MATERIALS RECYCLING FACILITY 600 WOODSTOCK AVENUE, ROOTY HILL

Response to Submissions - SSDA-29999239

Prepared for
CHARTER HALL
10 August 2022

Figure 4 Location of non-conforming loads

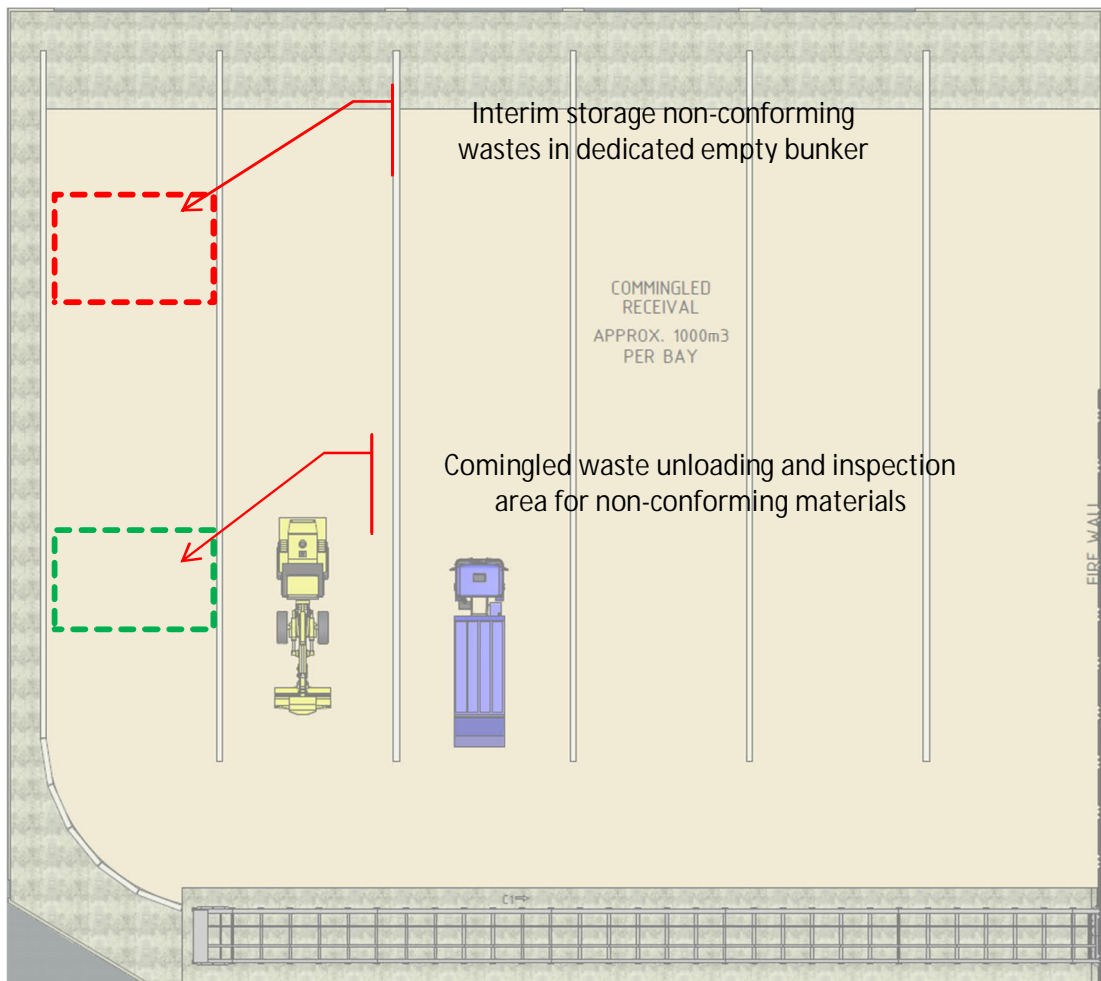
6	<p>Section 5.2.3.3 of the WMP advises that 'incoming materials will be inspected in the five bays in the main receival hall. Loads suspected to contain hazardous material will be isolated to a single receival bay until they can be inspected and photographed'. Please clarify if the single receival bay is one of the six commingled receival bays. If so, please clarify:</p> <p>(a) what measures are proposed in the event that all receival bays are occupied</p> <p>(b) what measures are proposed to ensure hazardous materials would not contaminate other wastes unloaded in the same bay.</p>	<p>Cleanaway (the future operator) will prepare a detailed Waste Management Operational Plan during the detailed design phase. The Applicant accepts a condition of consent for a detailed Waste Management Operational Plan to be prepared prior to the issue of a CC.</p>	N/A
7	<p>Section 5.2.3.3 of the WMP advises that 'inbound commercial cardboard loads will be deposited at the commercial OCC receival area, well away from other cardboard, so the load can be inspected for contamination or signs of a hot load, prior to being pushed onto the baler feed conveyor. Cleanaway's policies for hot loads and contaminated loads will be followed if an incident occurs'.</p> <p>Please clarify and detail the policies for hot loads and contaminated loads.</p>	<p>Section 5.2.3.3 of the updated WMP has been revised to provide greater detail in response to the issues raised by DPE:</p> <ul style="list-style-type: none"> ▪ If waste is identified that is not allowed on site (eg putrescible waste), the loader driver will immediately contact the weighbridge operator. If possible, the weighbridge operator will stop the vehicle that deposited the load and inform the driver that the load dropped is a material that is not accepted on the site. If the vehicle has already left the site, the vehicle's details will have been recorded in the weighbridge software. ▪ In either case, the weighbridge operator will notify the Operations Manager that the incident has occurred, the Operations Supervisor will then contact the customer. The details of the incident are entered into MyOSH and written notification provided to the customer. The loader driver will segregate any loads not accepted by the site and place 	Appendix F

them in the quarantine area. Waste in the quarantine area will be disposed of appropriately within one week.

Figure 4 from the updated WMP below shows the waste receipt and storage locations for non-conforming material. The interim storage location for non-conforming wastes may be located in any of the receivals bay and will only be stored in empty bays.

Figure 6 Location of bunkers, balers and storage areas

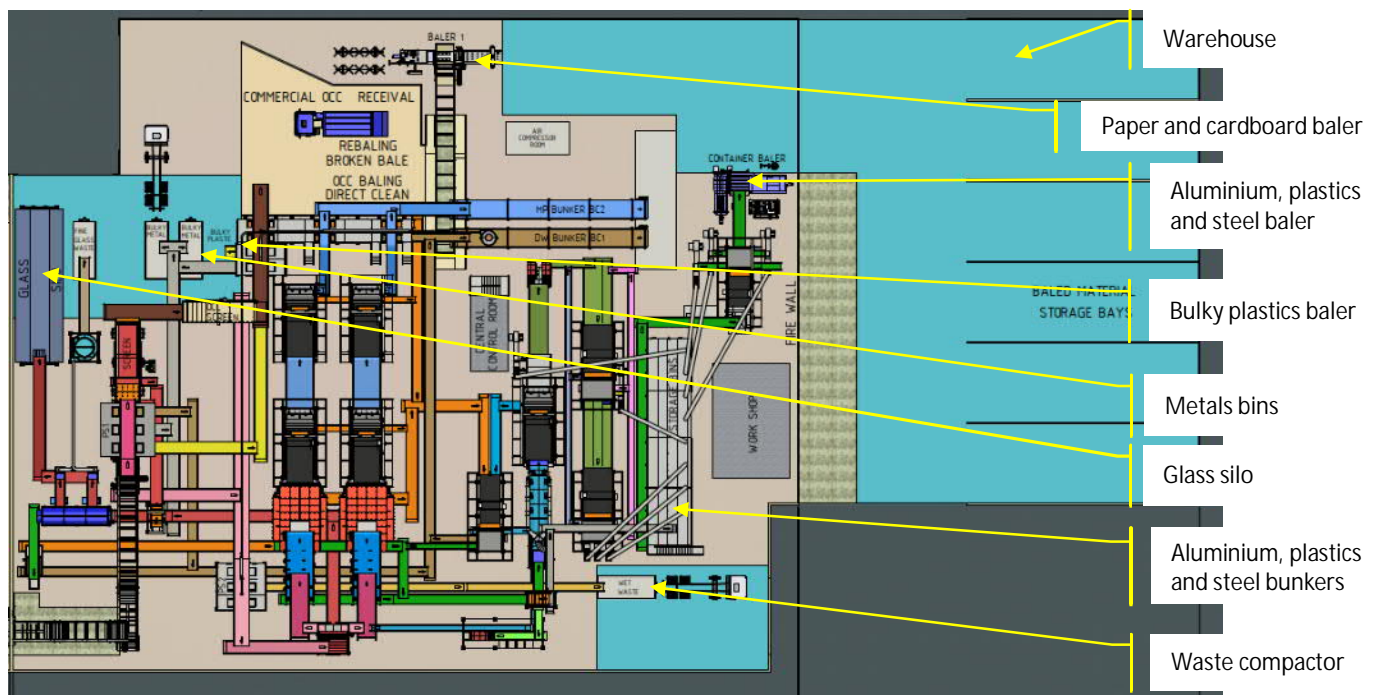
8 Section 5.2.2 of the WMP states that ‘the contents of the vehicles will be discharged into one of five bunkers on the southern side of the facility. A grab arm will remove any hazardous or undesirable items before a wheeled loader pushes the stockpiles onto a

conveyor that leads into the sorting and processing facility'. Please clarify:

(a) locations of the five bunkers and grab arm

(b) how co-mingled waste will be moved from trucks to the bunkers

(c) where the hazardous or undesirable items will be stored.

Refer to Row 5 of Table 5 and Appendix A of the updated WMP, which contains the below site plan. The location of the co-mingled receival bunkers, comprising five bunkers for mixed recyclables and one for a glass silo is located on the left of the plan. This is where the grab arm and conveyor belt is located to feed into the sorting area. Waste will be emptied into the bunkers directly from the trucks, which will reverse into the bunkers.
